CIVIL INTEGRATED WATER MANAGEMENT PLAN OPAL HEALTHCARE NARWEE PARKLANDS CARE COMMUNITY

**For SSDA
May 2023
Revision 6**

This Addendum /Integrated Water Management Plan has been prepared to support the Response to Submission Report for the Narwee Parklands Care Community State Significant Development Application (SSD-45024776) located at 59-67 Karne Street North, Narwee. The NSW Department of Planning and Environment (DPE) placed the Environmental Impact Statement and the accompanying technical documentation on public exhibition from 14 February 2023 until 13 March 2023. During the exhibition, a total of 22 submissions were received in response to the public exhibition of the EIS. These included submissions made by the State and Local Government agencies, authorities, as well as the general public.

22M21_DA_C100 | 03

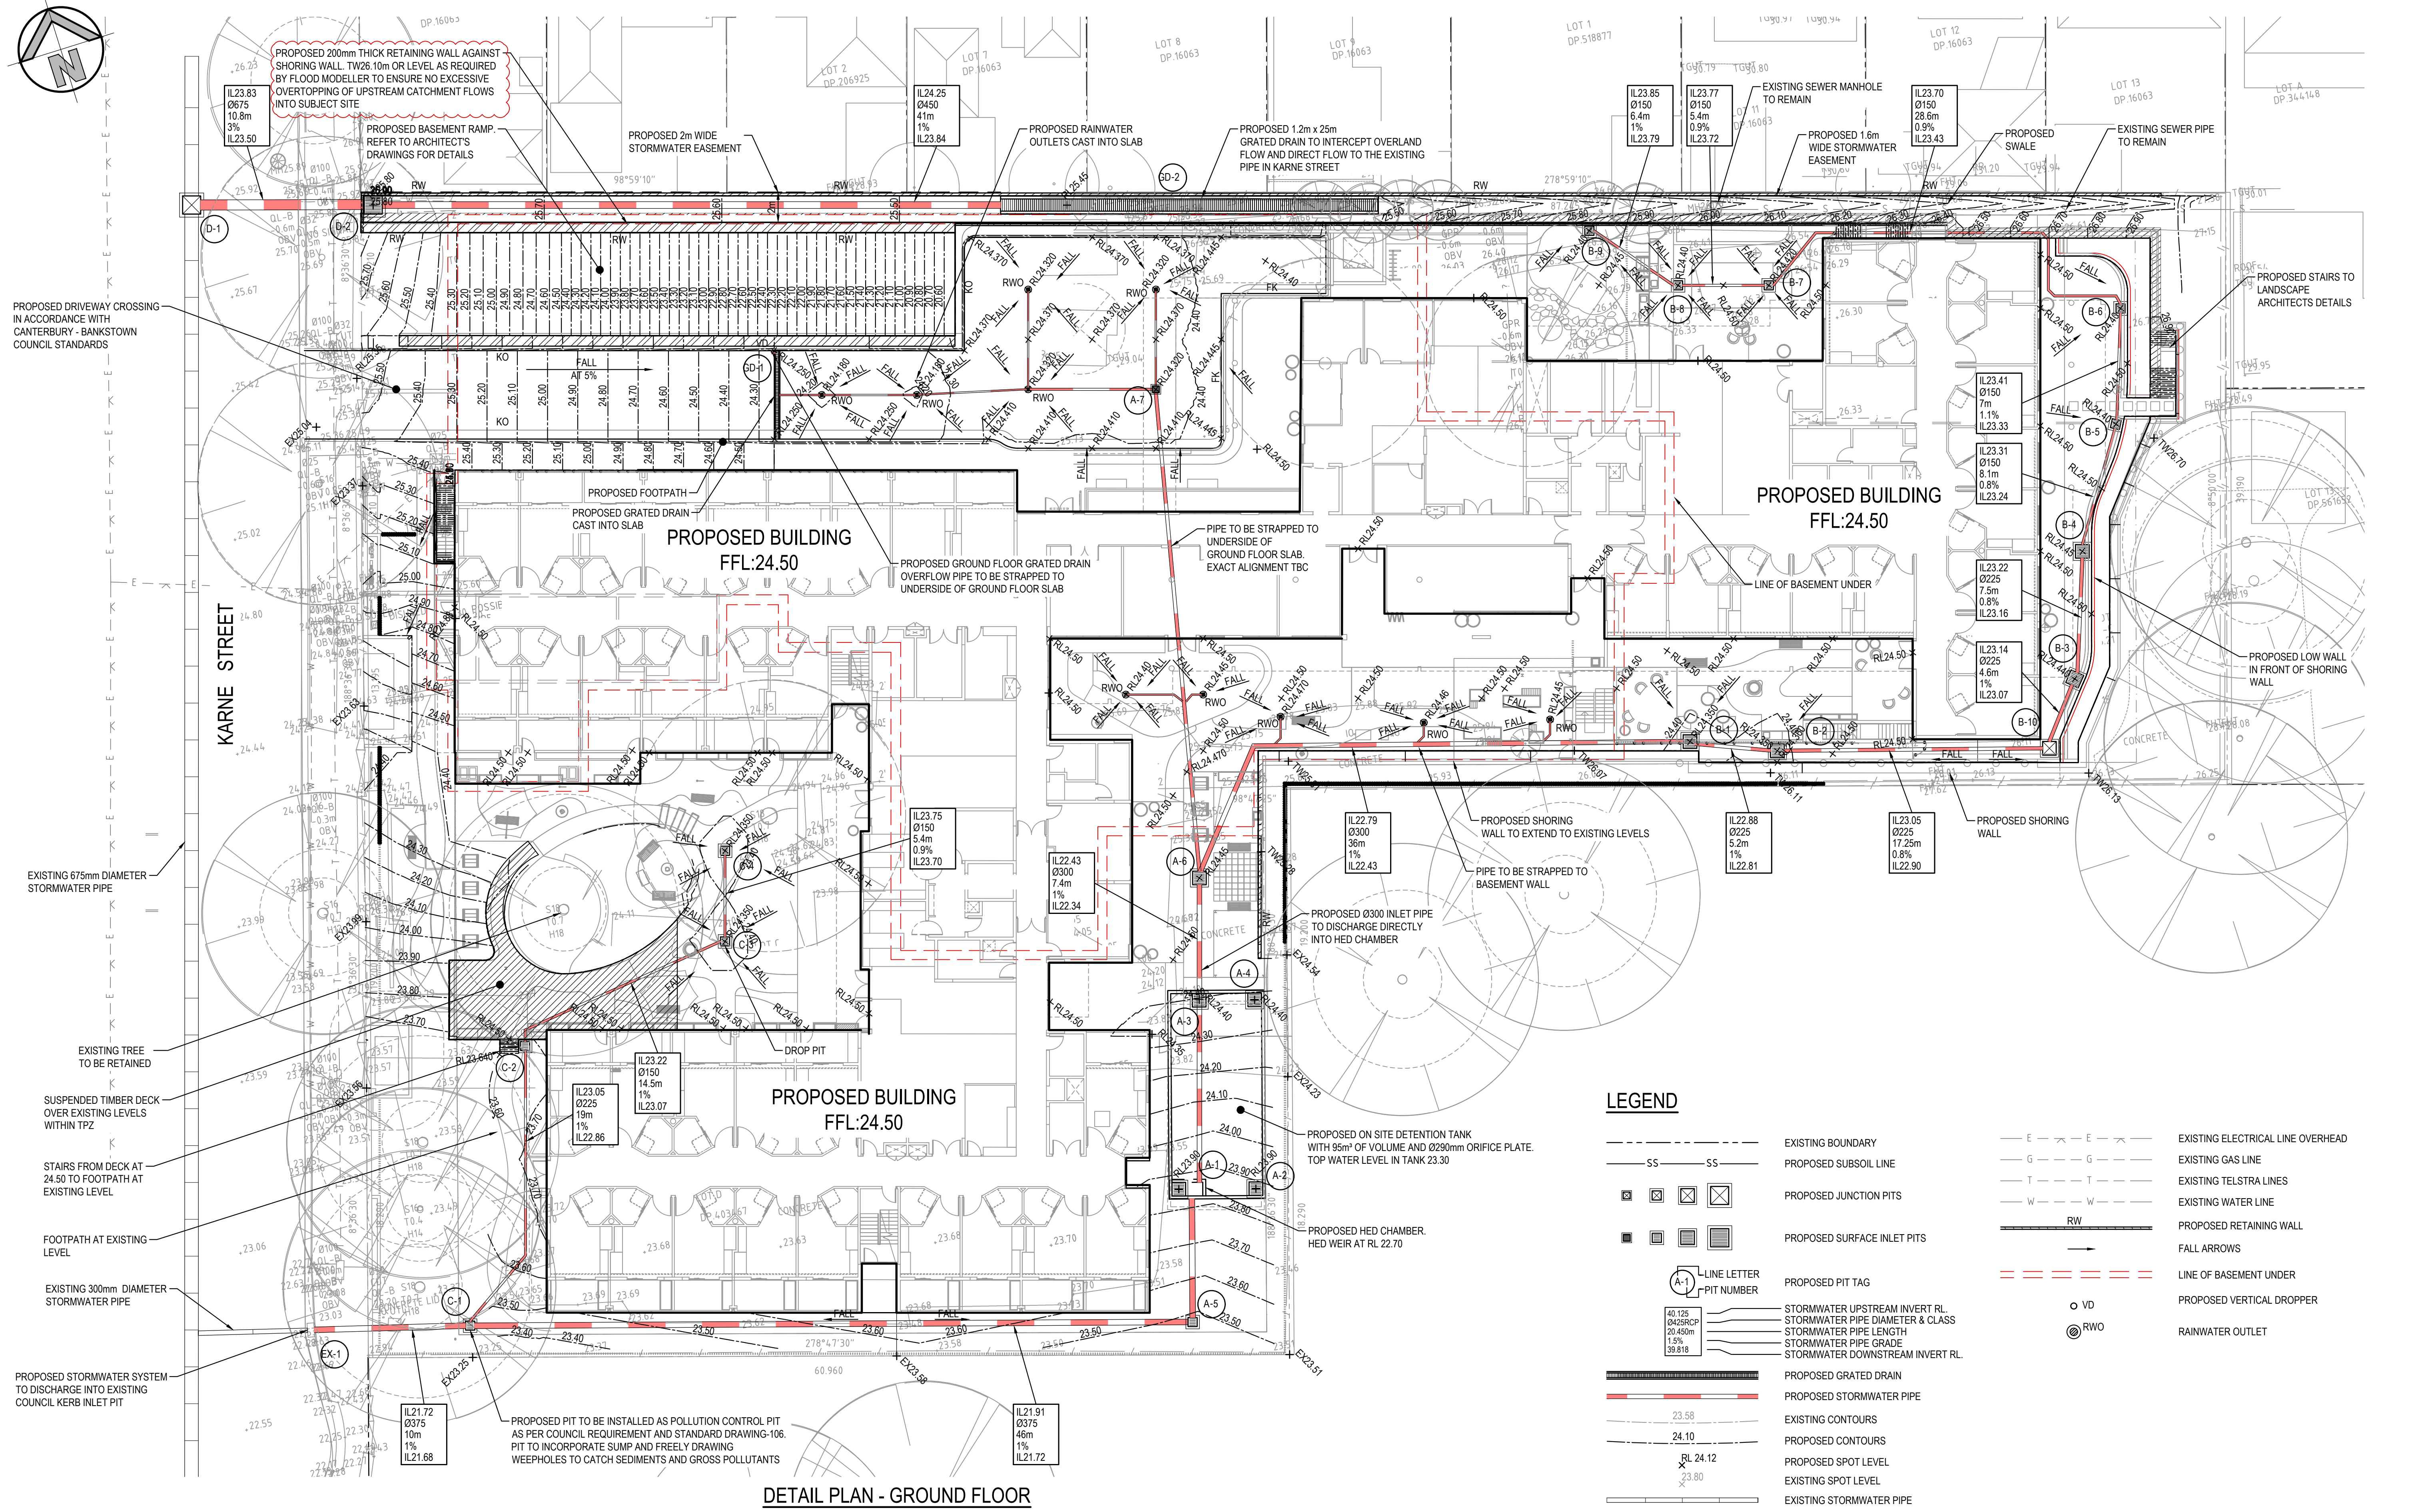
Ocean guard pit baskets and pollution control pits are not supported. It is requested a single gross pollutant trap is installed in lieu.

Refer to drawing C100 which now shows a gross pollutant trap to be installed in the southern part of the site. All reference to pit baskets and pollution control pits have been removed from the design.
